An
Bord
Pleanála

Inspector's Report ABP-320327-24

Whether or not: (a) Structure No. 1: Gate Lodge A and Gate Lodge B; (b) Structure No. 2: semi-detached agricultural storage facility; (c) Structure No. 3: detached agricultural maintenance/storage facility; (d) Structure No. 4: electricity distribution building; (e) Structure No. 5: open fronted agricultural storage shed; (f) Structure No. 6: former agricultural building, now used to accommodate protected persons; (g) Structure No. 7 and Structure No. 8: pavillion and kitchen building; (h) Structure No. 10: former Belfry Building; (i) Structure No. 11: concrete paved area adjacent to structure no. 10 and 12; (j) Structure No. 12: accommodation block no. 1; (k) Structure No. 13: Art O'Neills building; (l) Structure No. 14: car park adjacent to the former Belfry Building; (m) Structure No. 15: large gravelled area to the north east of the holiday village; (n) Structure No. 16: accommodation block no. 2 and (o)

Kippure Lodge and Holiday Village,
Kippure Estate, Manor Kilbride,
Blessington, County Wicklow.

Drawing file: 320327 Referral / PL-10-01-KE Structure 10.pdf

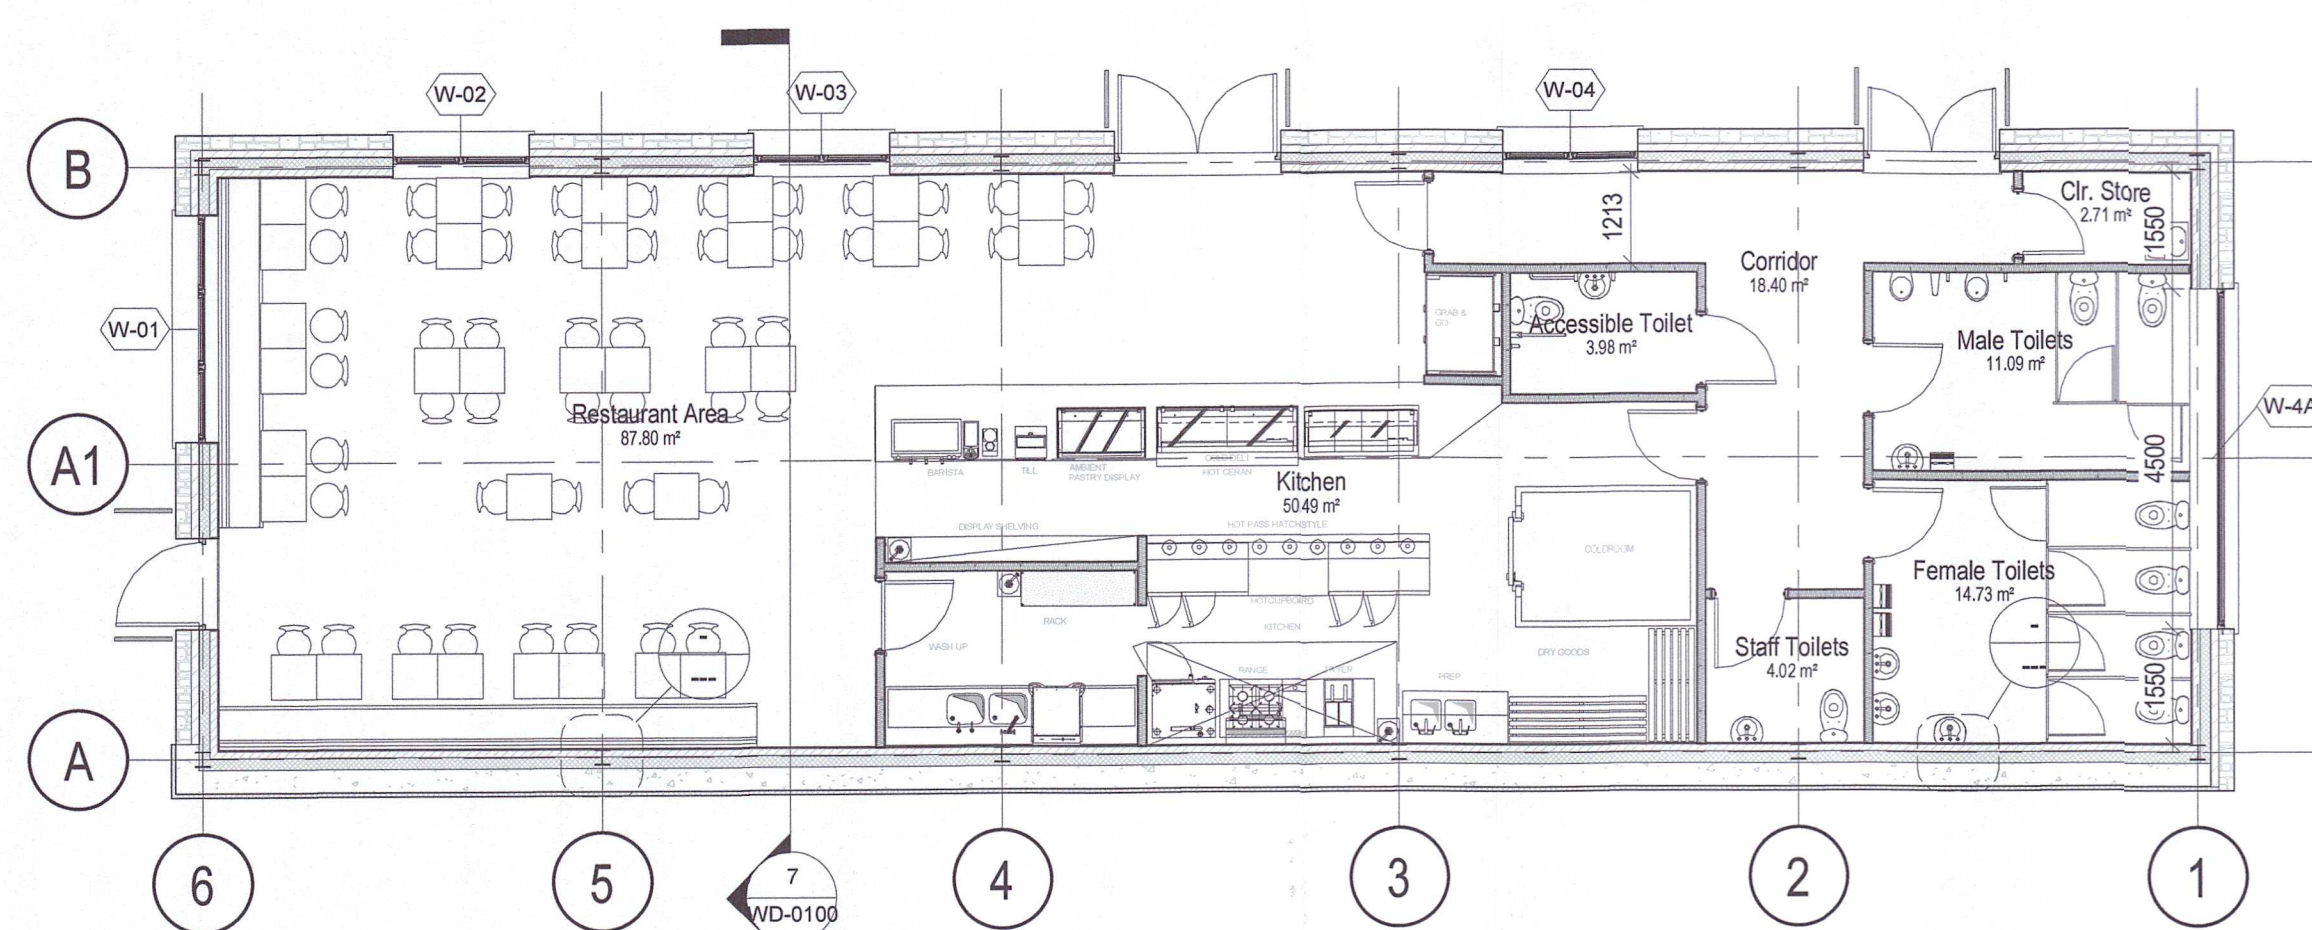
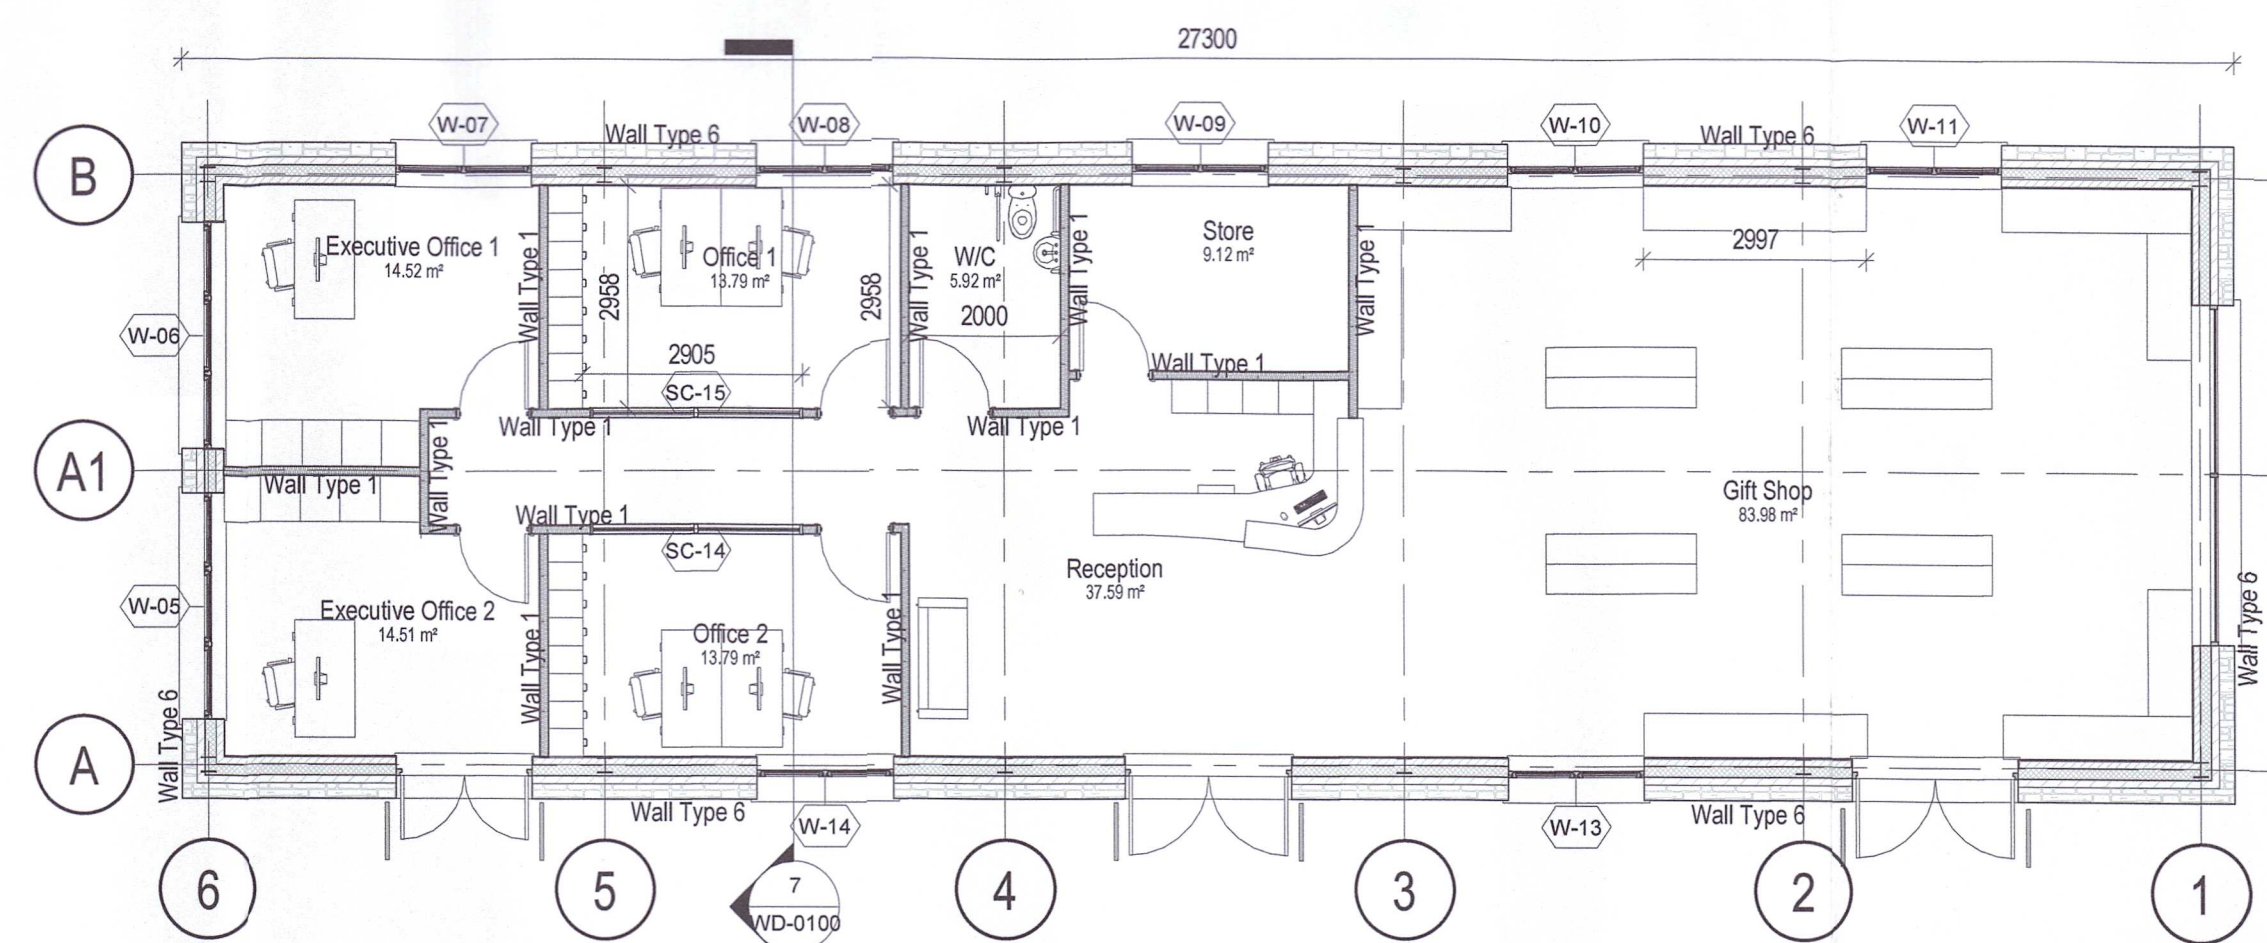
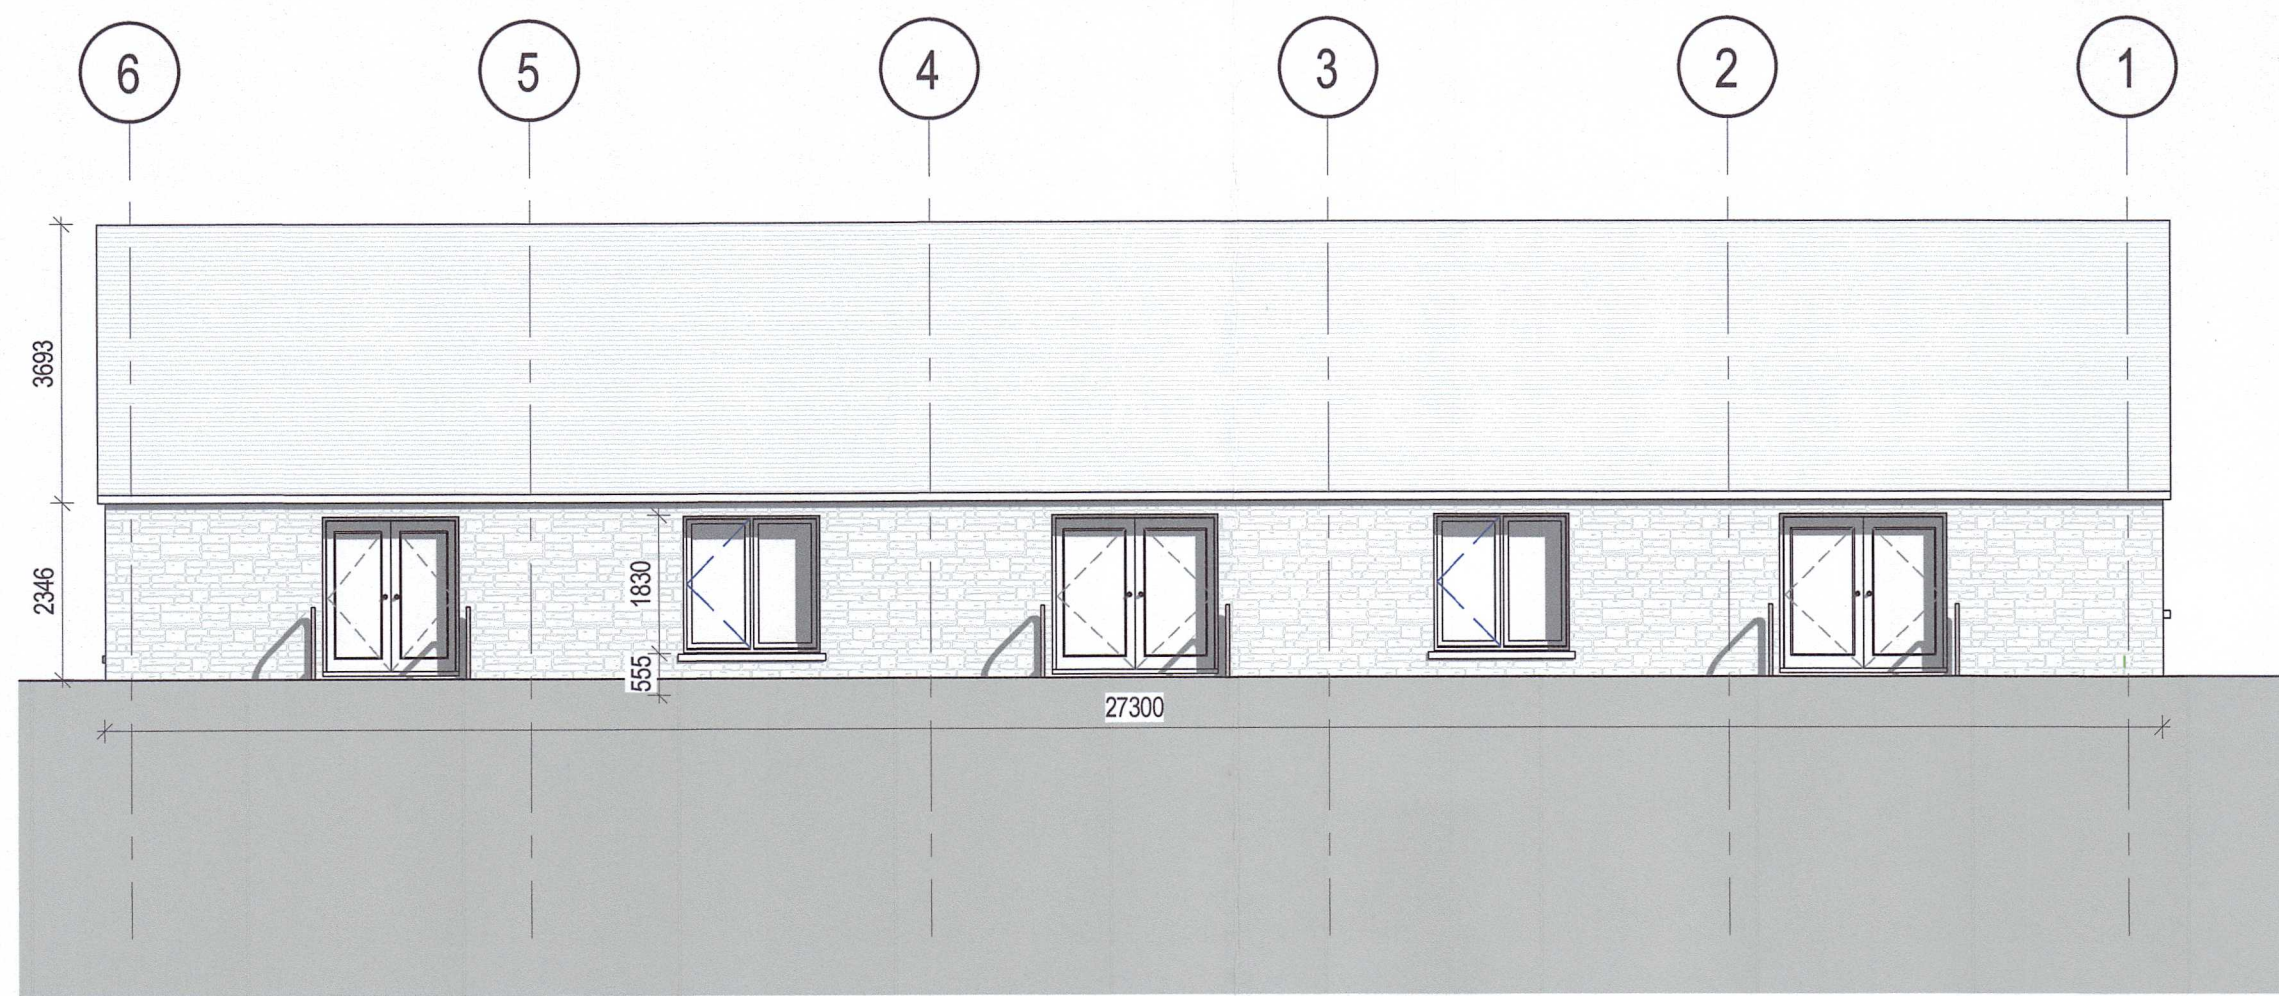
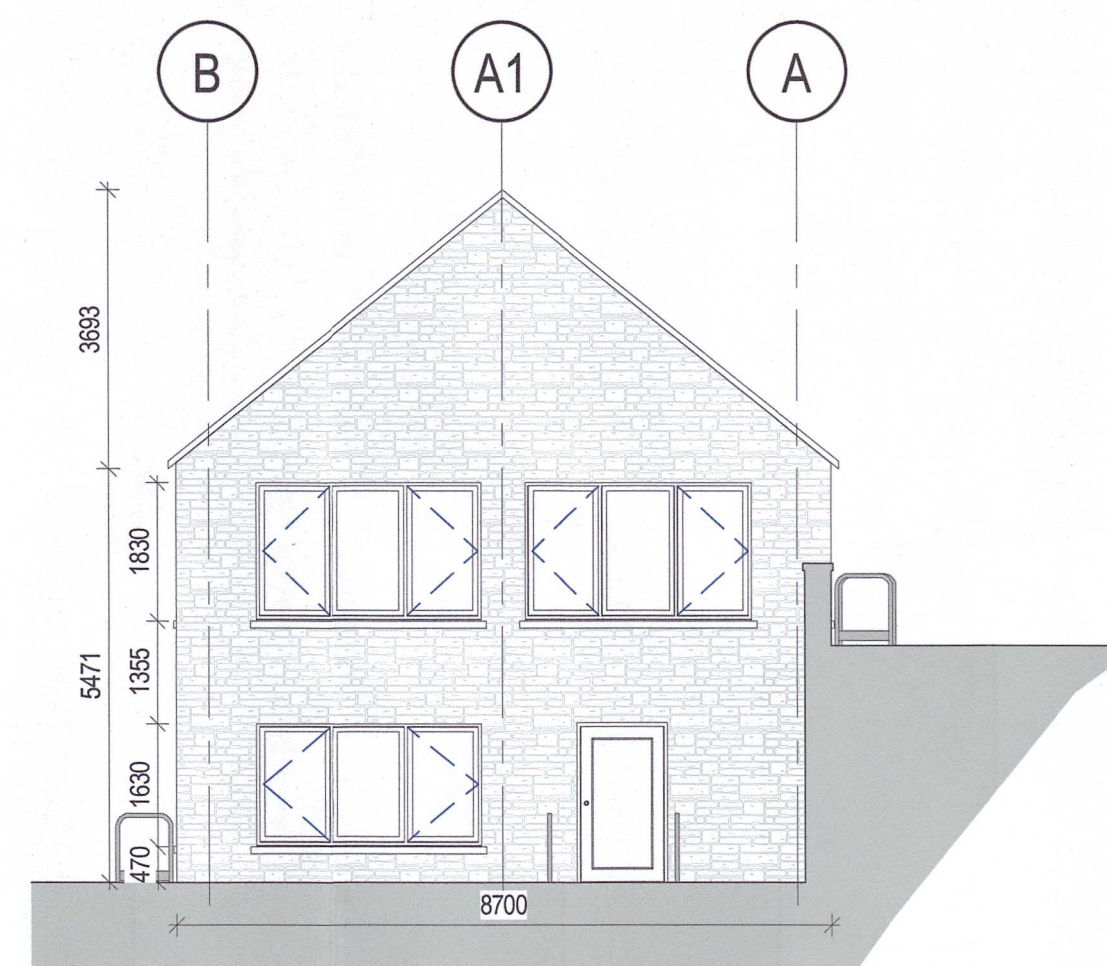
This building was constructed in c. 1830 and predates the Planning Acts and modern planning law. The structure has been upgraded and renovated as exempted development under Section 4(1)(h) of the PDA. Permission was also granted under Reg. Ref.05/2792 for the refurbishment of the Belfry Building and its use as a backup facility for outdoor facilities.

The structure has been extended and altered by reference to changes in height, length and width. The nature of the works would not comprise maintenance, improvement or other alteration and result in the structure being materially different to the former structure. The works have significantly altered the external appearance of the structure so that it is inconsistent with the character of the structure.

There are no other exemptions available for this structure. Therefore, it is development and is not exempted development.
